City of Portland
 Development Review Application
 Planning Division Transmittal Form

Application Number: 2014-154 **Application Date:** 08/20/2014
CBL: 292 D006001 **Application Type:** Level II Site Plan
Applicant: Paris Farmers Union / Fred Rolfe
Project Name: Paris Farmers Union
Address: 55 WARREN AVE
Project Description: Occupy existing 18,900 sq ft building for storage and retail sales.
Zoning: R5/B4

To: FILE
From: Jean Fraser
Subject: Application ID: 2014-154
Date: 10/2/2014

Comments Submitted by: Marge Schmuckal/Zoning on 10/2/2014

SHEET **C2**

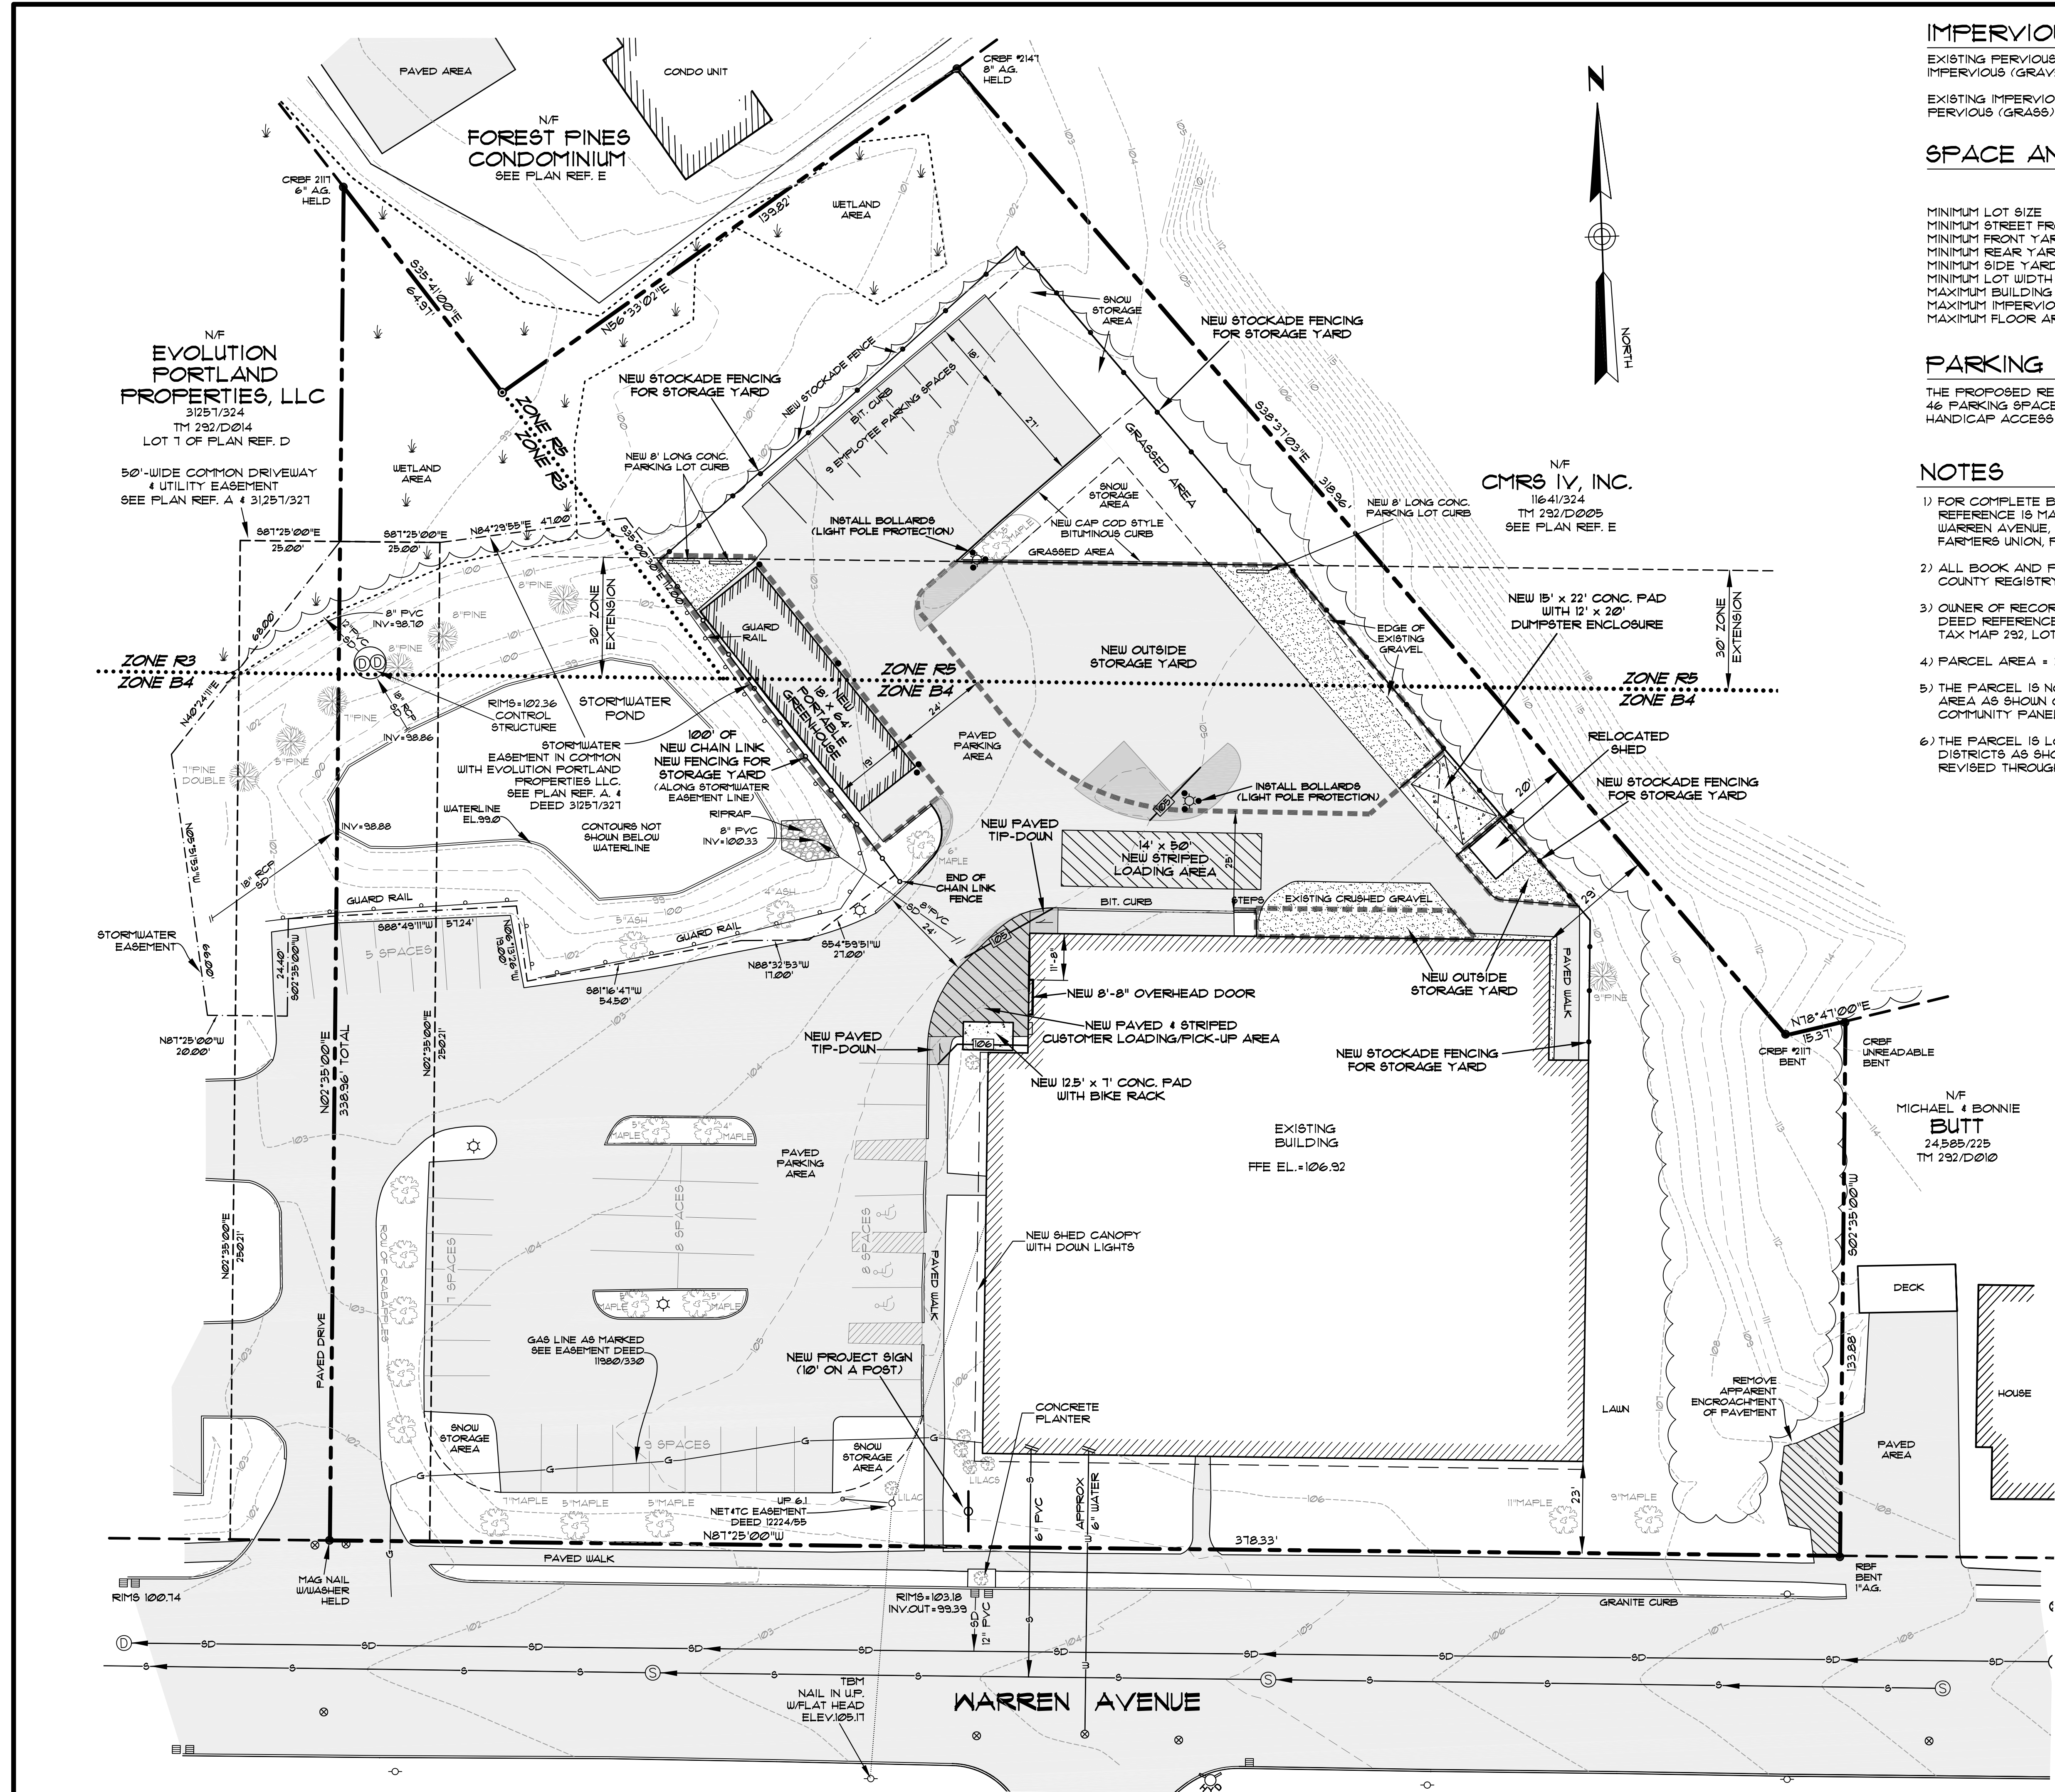
The review of the latest submitted plans (9/29/14 shows the reduced and relocated greenhouse. All the B-4 zone requirements are being met, including parking, impervious surface and setbacks. There should be some on-site deliniation as to wher the 30' zone line extension falls on the lot so that business materials don't over reach the allowed business zone area. Separate permits are required for any new signage.

Also, the most recent plot plan shown with the zone lines delineated shows a 24' x 70' greenhouse. However, your e-mail from you & Mike dated 9/19/14 states that a 18' x 64' greenhouse will be used instead. I have used the greenhouse at 18' x 64' for determining parking requirements. I will want to see this on the next rendition of site plan. If the greenhouse changes in size, the parking requirements will be changed.

TOPOGRAPHIC SITE PLAN

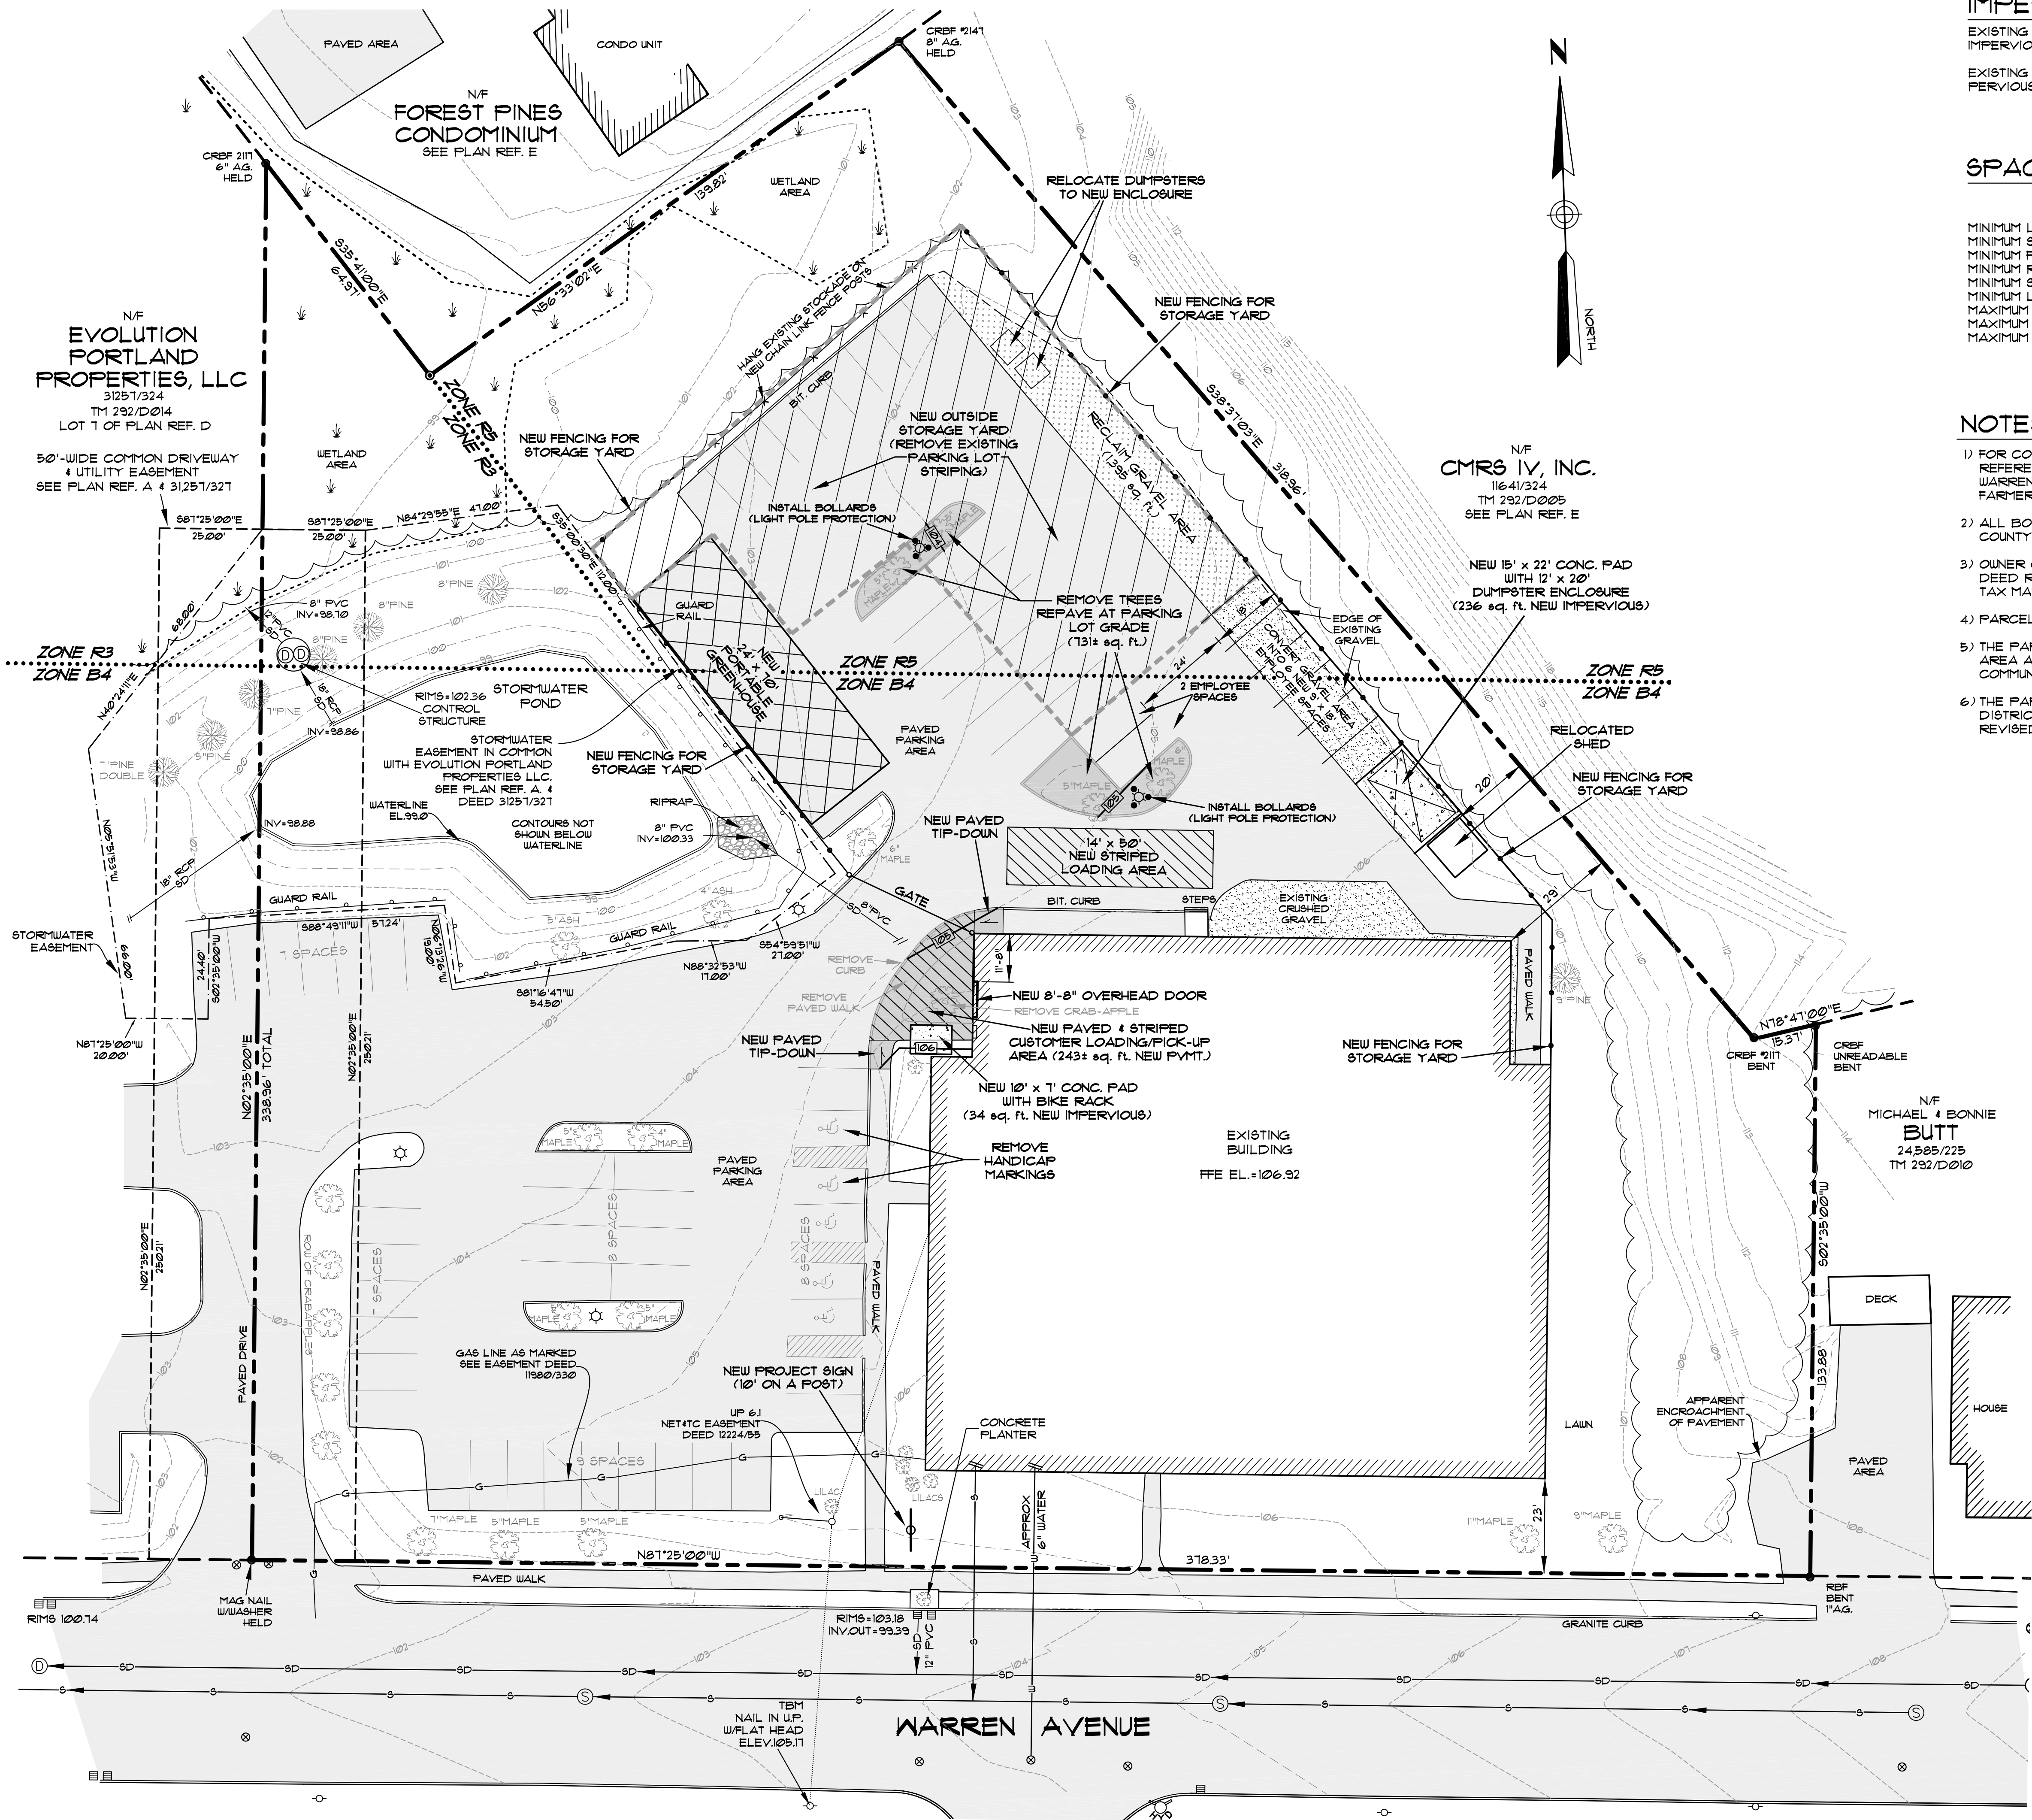
The preliminary review of what was submitted with the zoning lines on it, still shows that the 24'x70' trailer to be 2' into an R-5 residential zone where business uses are prohibited. It also looks like part of the rear parking lot will have outside storage for the business use which again is also not allowed in residential zones.
